A41 - Oxford Road

Bicester

Linsig Report

August 2018

**Scenario 1: '2026 PM BTM + Committed'** (FG11: '2026 PM BTM + Committed', Plan 1: 'Control Plan')  
**Network Layout Diagram**

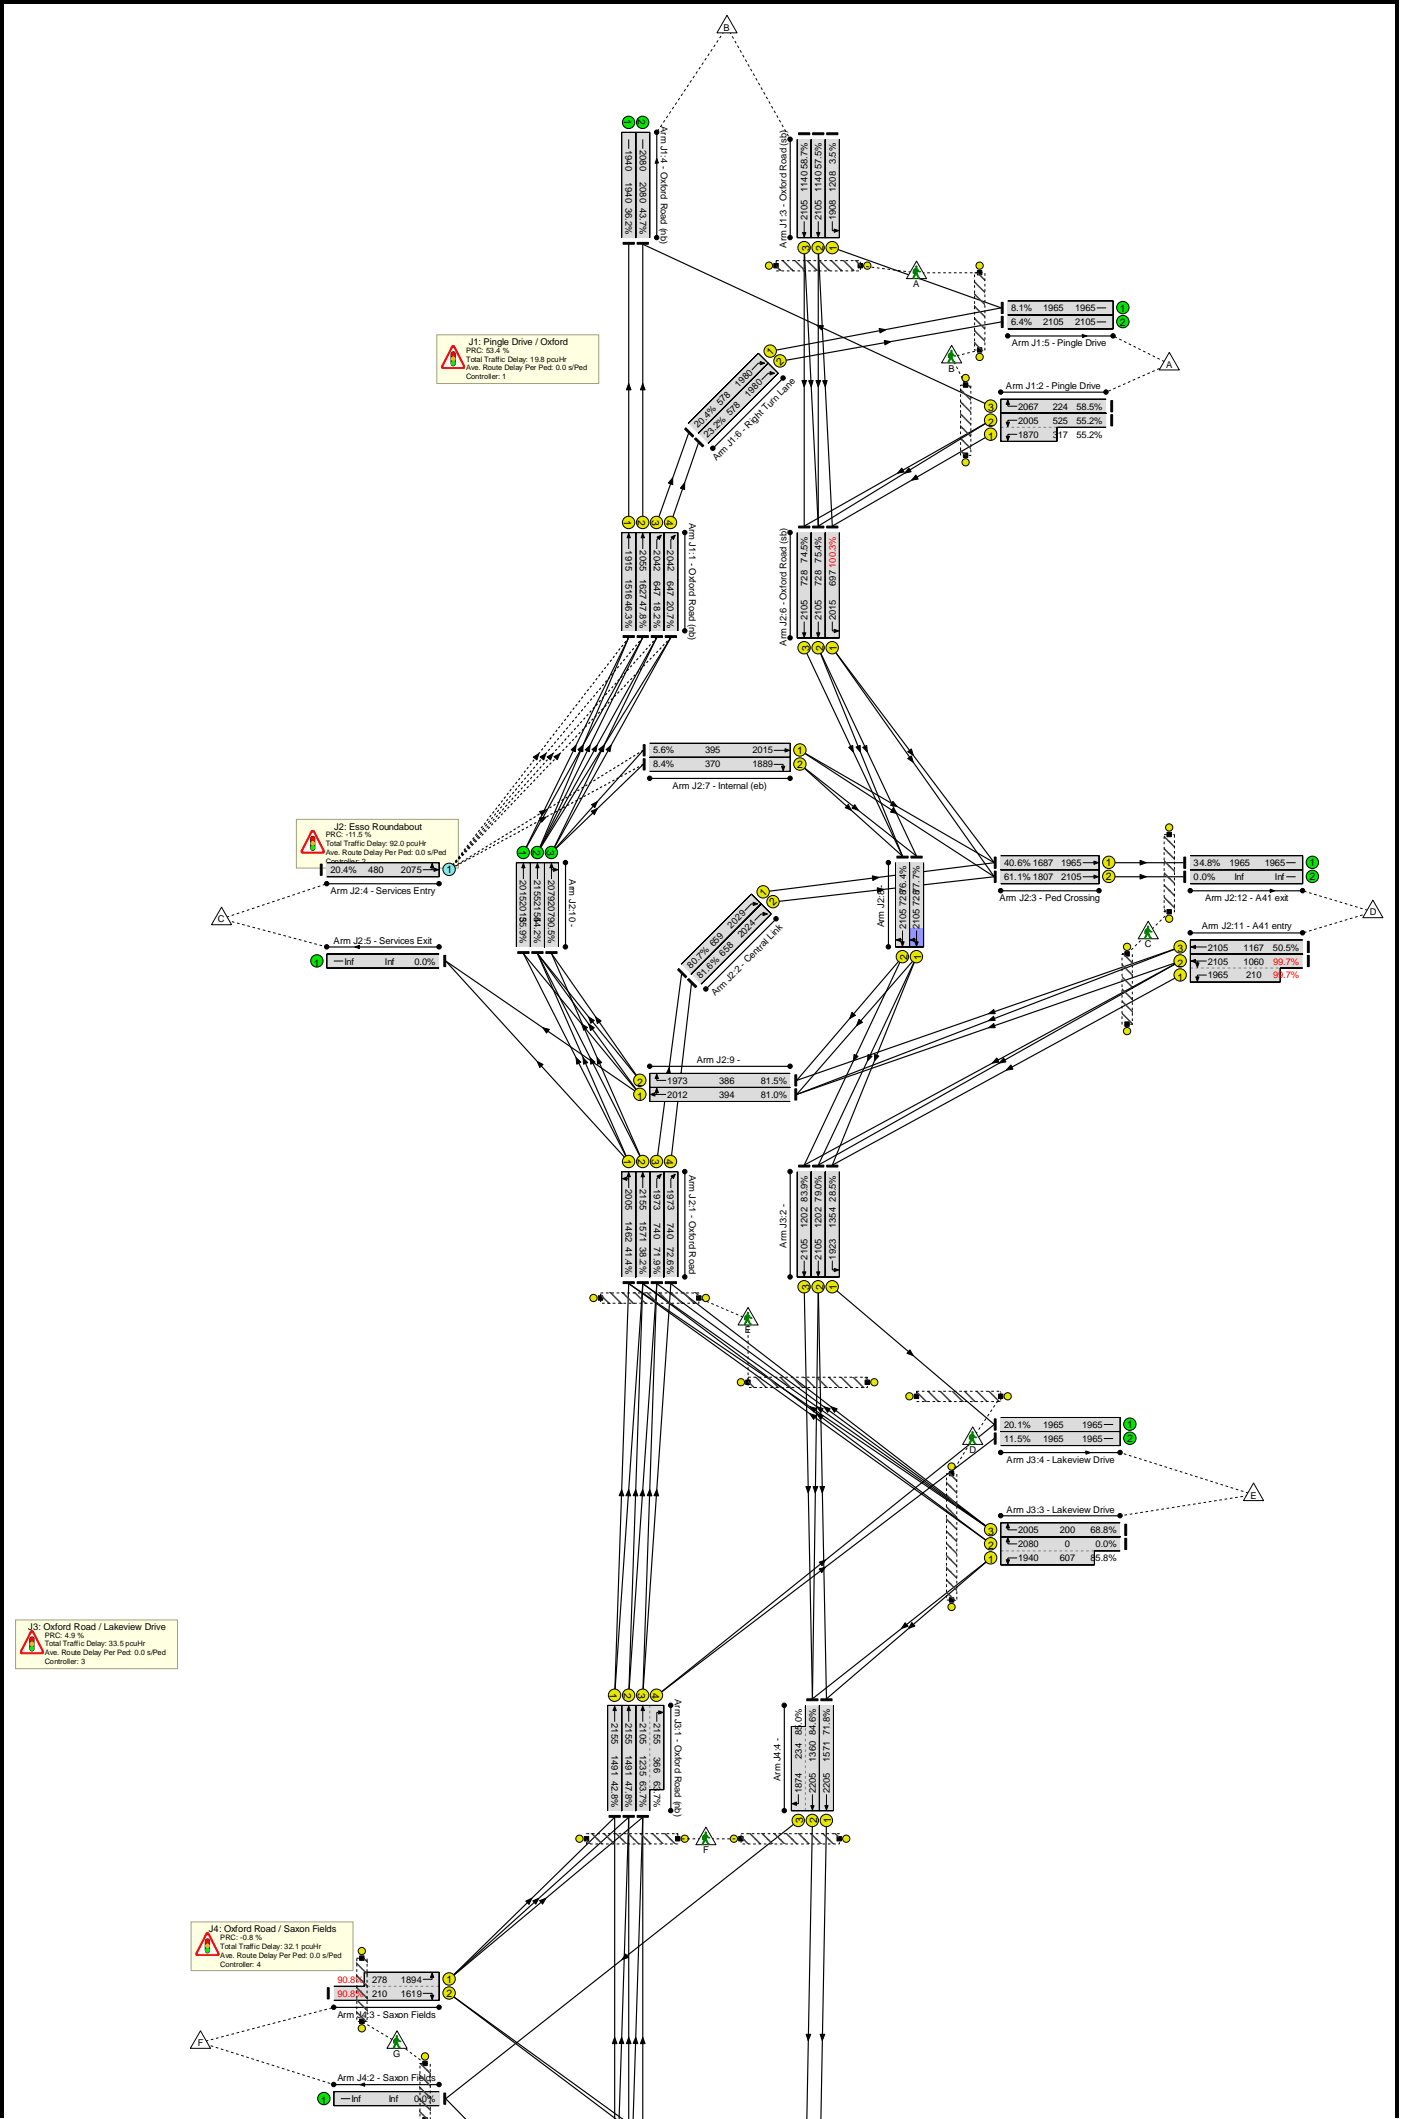
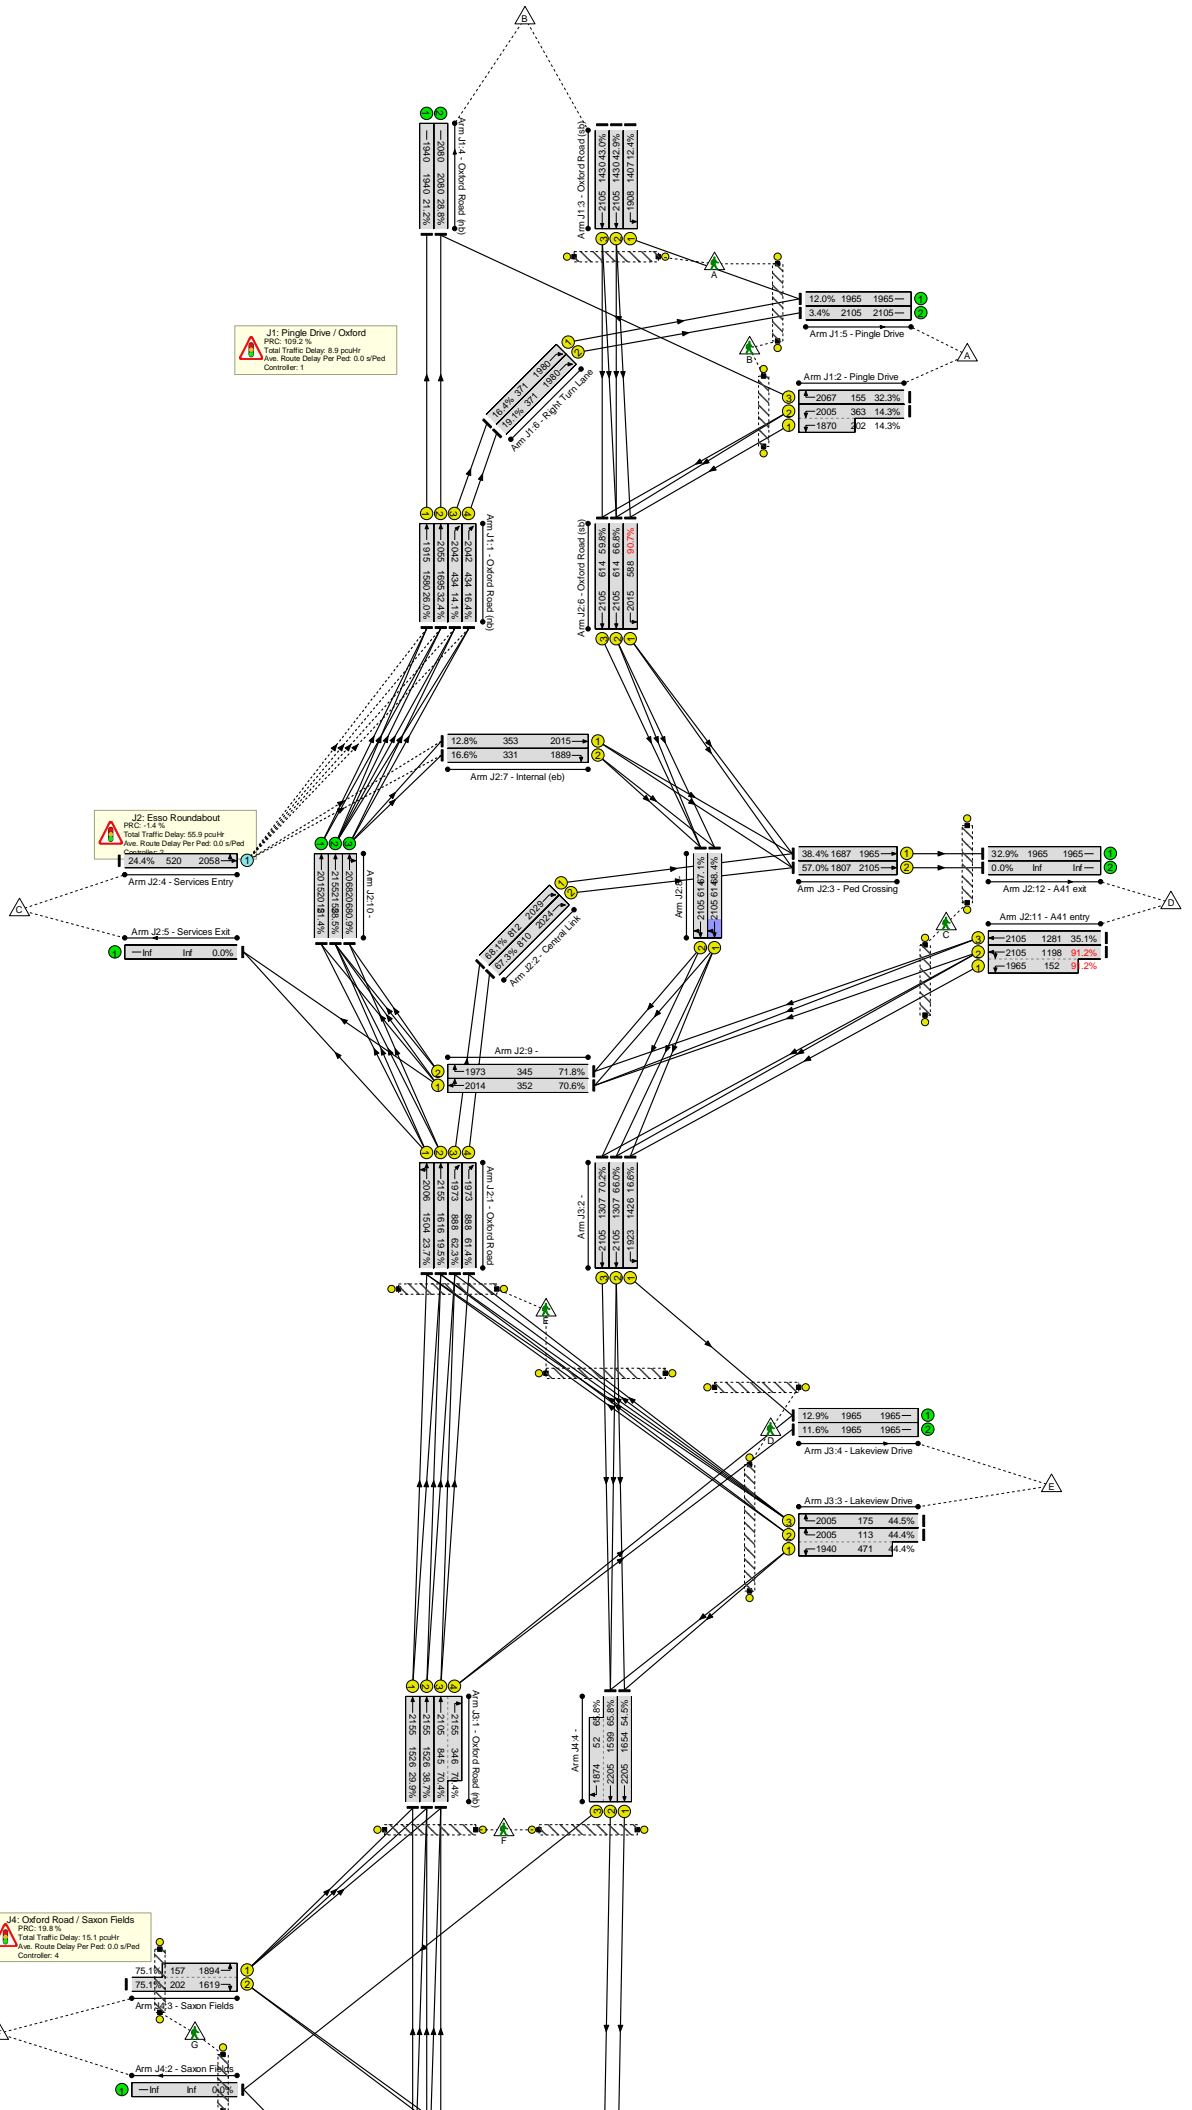
Where it has been possible to measure lane widths from scale plans, the lane widths used in the calculation of saturation flow appear to be consistently wider than the measured lane widths. Although at the scale shown in some plans, it is hard to be accurate, the difference appears to be greater than 0.5m on almost all Oxford Road lanes. This will result in an over optimistic calculation of saturation flows in both models.

Mean cruise times on many link connectors seem higher than would normally be expected, particularly short link connectors. This could result in a distortion of progression through the network, and making the timings unreliable for CLF in particular. This should not have an impact on overall capacity results, but may make queue length and delay values less accurate.

Saturation flows are generally higher than would normally be expected. In particular, where there is only one lane serving any given destination, the lane should be treated as a nearside lane in the saturation flow calculations. This is because slow vehicles will delay the entire route flow, unlike multiple lane / route choice approaches, where faster vehicles are able to overtake in the offside lane.

Arm J1:4 Oxford Road (nb) has no pedestrian crossing across it, despite signalled crossing across southbound. This may be accurate, but it would be unusual.

We would recommend that the errors in the model be corrected and the modelling resubmitted.
